# Rezoning Transportation Analysis

Petition Number: 2020-084

General Location Identifier: Tax ID 03737317

The 9 acres site is located on Reams Road just North of Sunset Rd. in between two collector roads, Northpark Blvd. and Lawnmeadow Dr. Currently, Reams Rd. and the proposed street network within the site do not meet City standards. The proposed multi-family development will not increase connectivity throughout the area, however, it should not have a large impact on the existing roadway network. Additionally, a 5-foot bike lane is being proposed conforming with the City's BIKES Plan as well as a sidewalk connection to the surrounding pedestrian network. The petitioner should revise the site plan to meet the ordinance requirements and the outstanding items listed below.

FILE NUMBER:
7734-00
 DATE: 05/04/2020
RZ-2

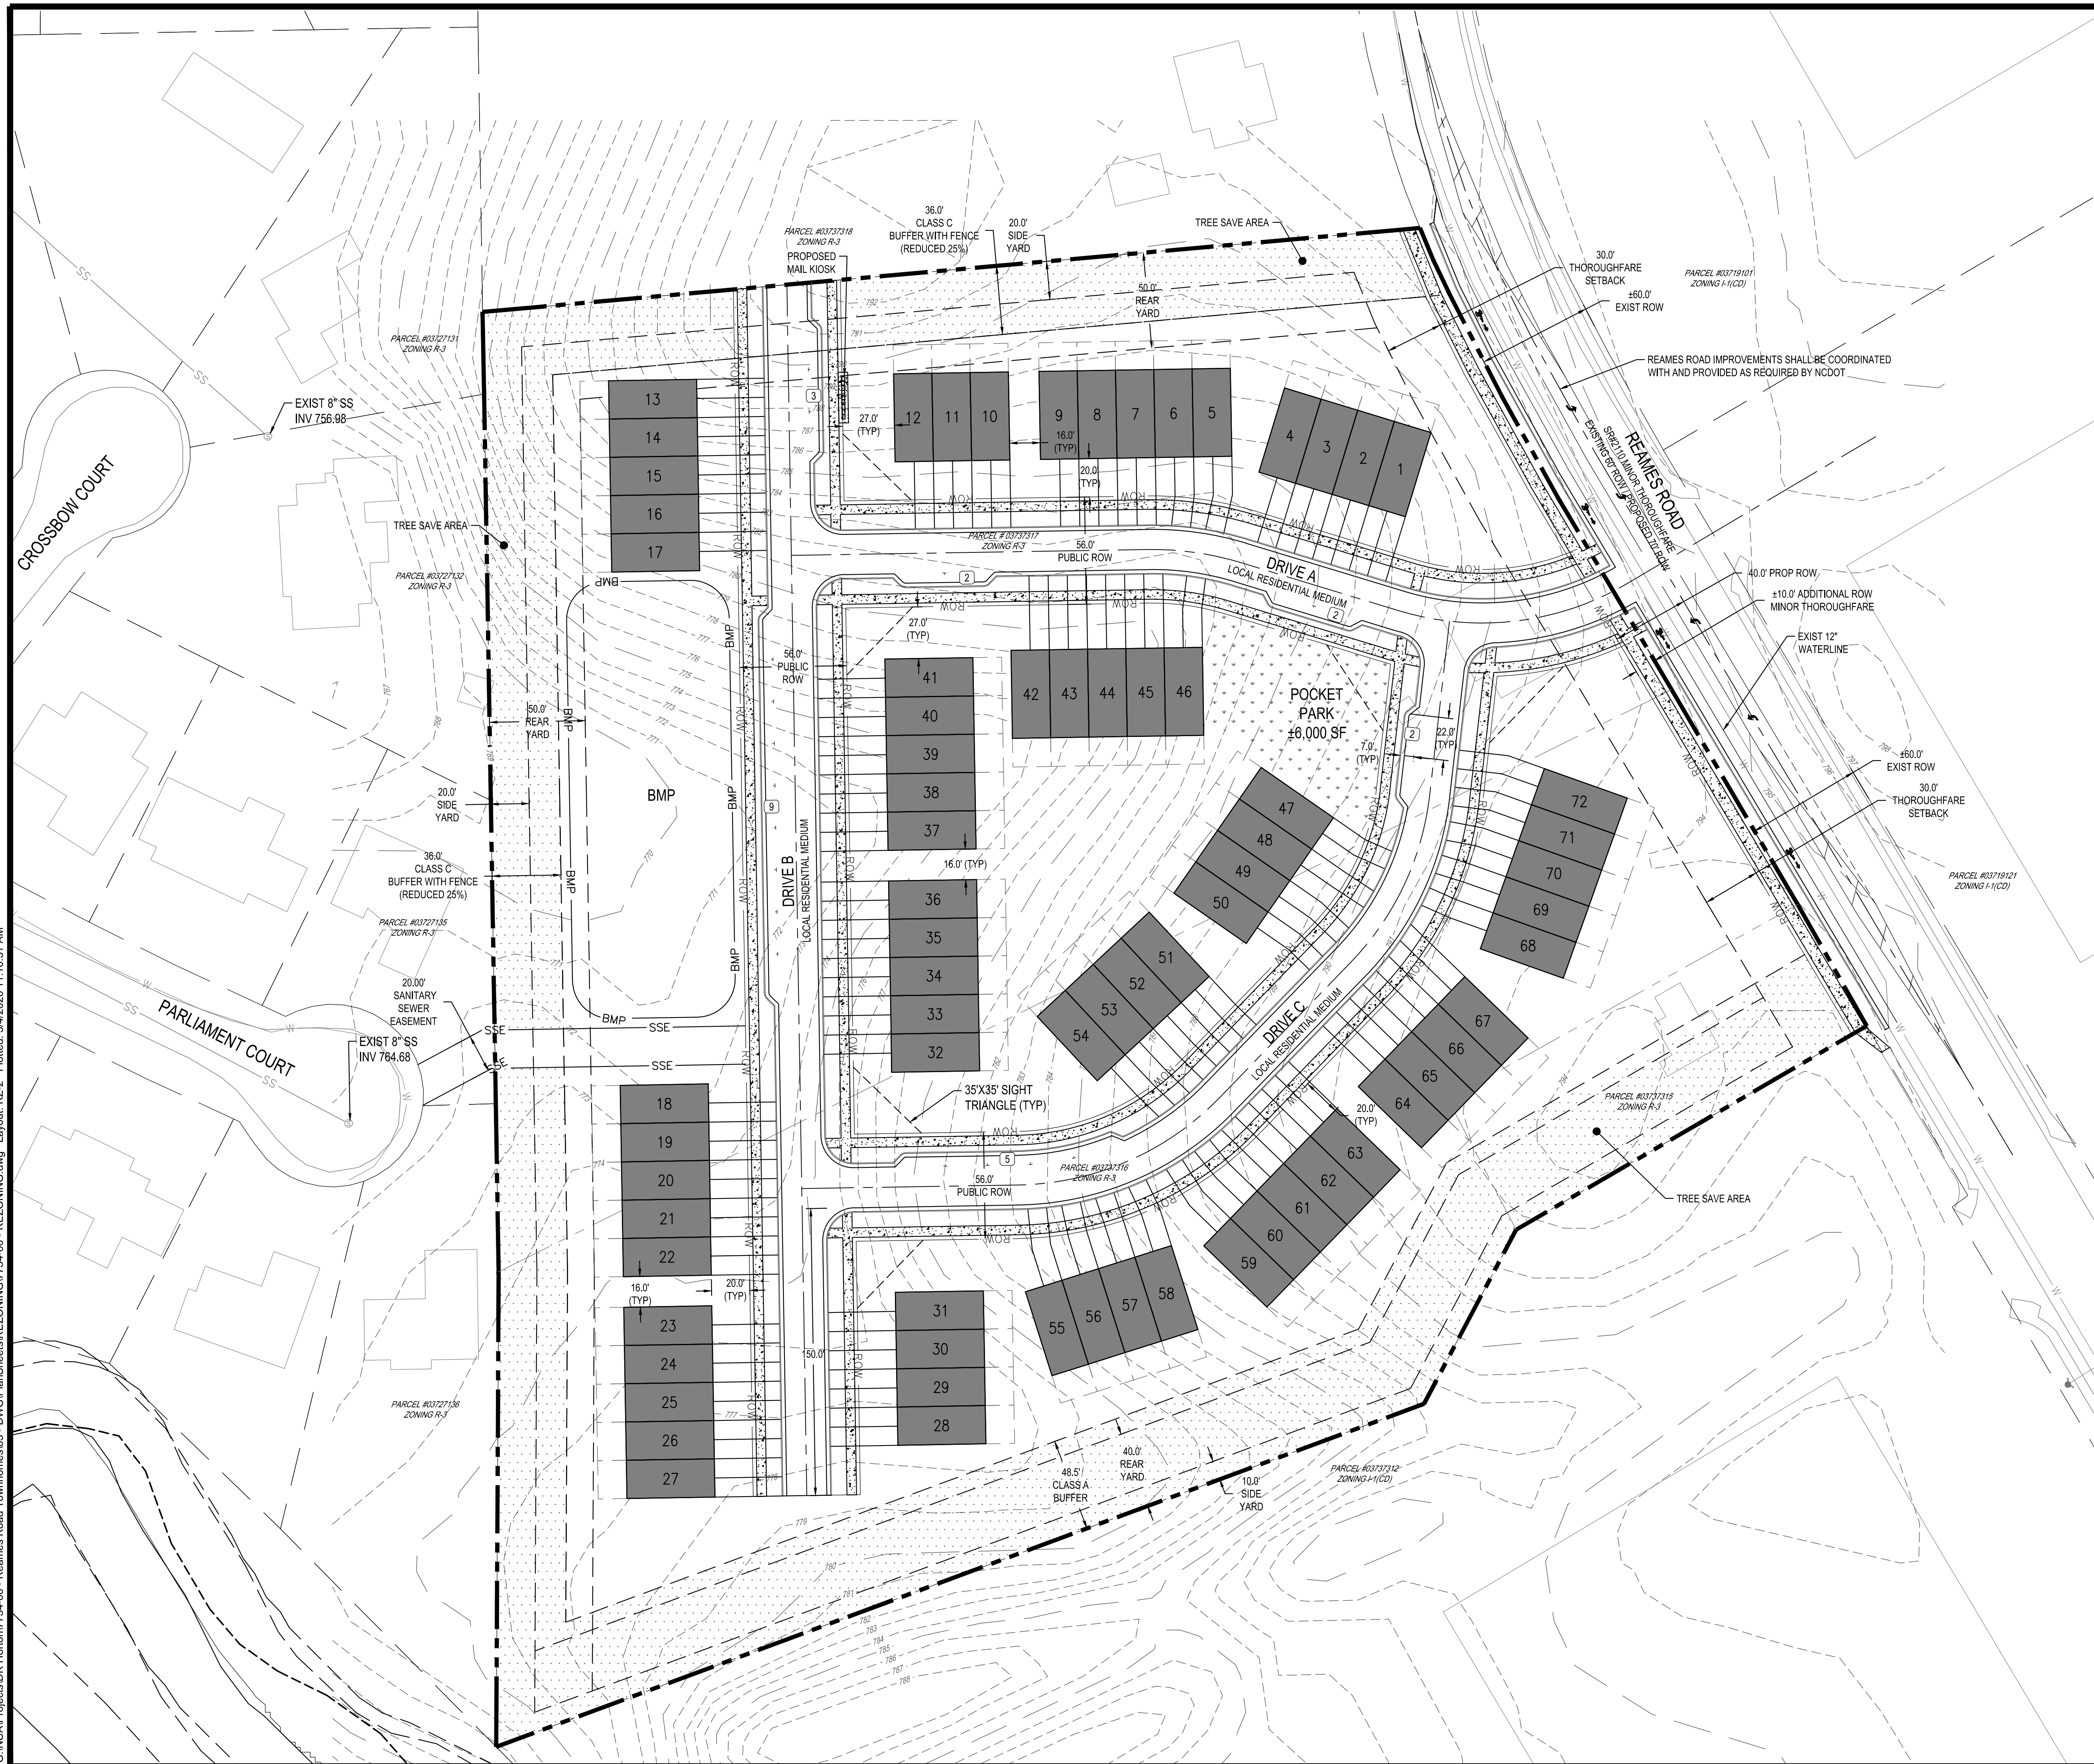
- a. Reams Road: The future location of back of curb and gutter is located 24 feet from the centerline of the road.

The site plan should show the curb and gutter labeled and dimensioned from the centerline for each road.

3. The petitioner should revise the site plan and conditional note(s) to commit to changing the cross section of each internal public road from Local Residential Medium (U-02) to Local Residential Wide (U-03). The site plan should label and dimension the right-of-way from the road centerline.

4. The petitioner should revise the site plan and conditional note(s) to commit to construct an 8-foot planting strip, and 6-foot/8-foot sidewalk on Reams Road. The site plan should label and dimension both items from the back of curb and gutter and road centerline.

6. The petitioner should revise the site plan to add a turnaround at the southern terminus of proposed Public Street B.
